Our Case Number: ABP-314724-22

Re: Railway (Metrolink - Estuary to Charlemont via Dublin Airport) Order [2022]
Metrolink. Estuary through Swords, Dublin Airport, Ballymun, Glasnevin and City Centre to Charlemont,
Co. Dublin

Our Ref : 18-020.047.docx
Your Ref :
E-mail : r.osborne@waterman-moylan.ie
Date : 12 January 2023

**Re : Railway (Metrolink–Estuary to Charlemont via Dublin Airport) Order 2022
70 St Stephens Green (formally known as Hainault House Nos. 69-71 St. Stephens
Green, Dublin 2)**

### Figure 14.2 Groundborne Noise from Tunnel Boring Machine Sheet 7 of 7

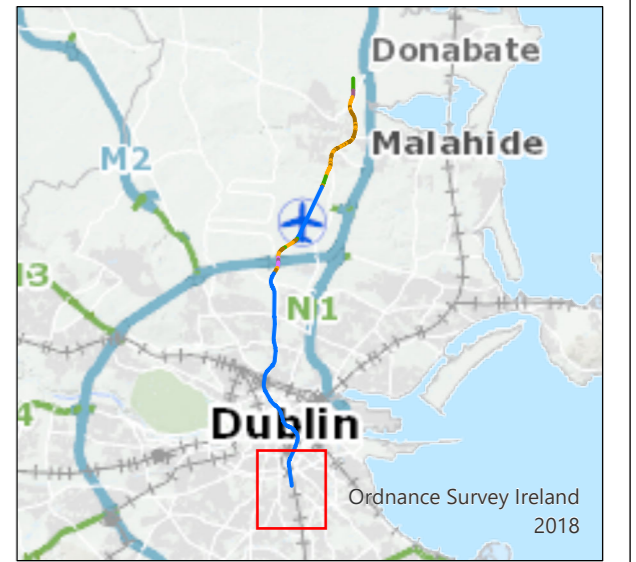
- a) Metrolink has assessed the "*Groundborne Noise from Tunnel Boring Machine*" and presents its findings on drawing no. ML1-JAI-EIA-ROUT-XX-DR-Y-14009 (a copy is attached to this submission). This drawing indicates MetroLink will generate an additional 50db directly under the location of our client's building which is unacceptable.

Drawing Title
Figure 14.6 Groundborne Noise from Operation
 Sheet 7 of 7

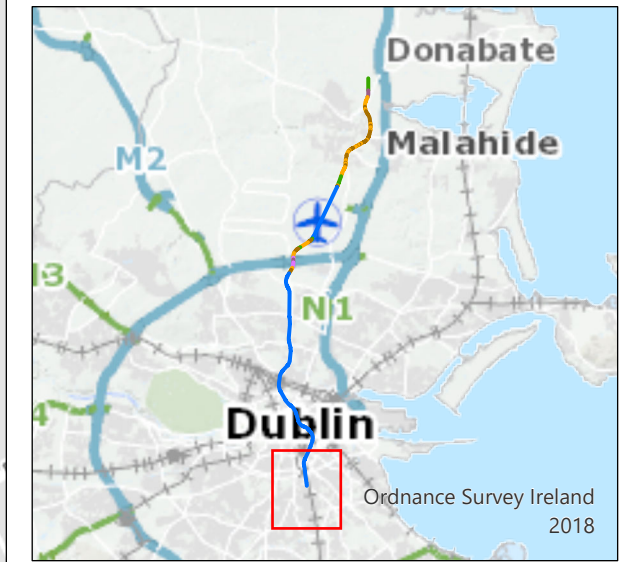
- a) Metrolink has assessed the "*Groundborne Noise from Operation*" and presented its findings on drawing no. ML1-JAI-EIA-ROUT-XX-DR-Y-14041 (a copy is attached to this submission). This drawing indicates MetroLink will be generating an additional 35db directly under the location of our Clients building which is unacceptable.
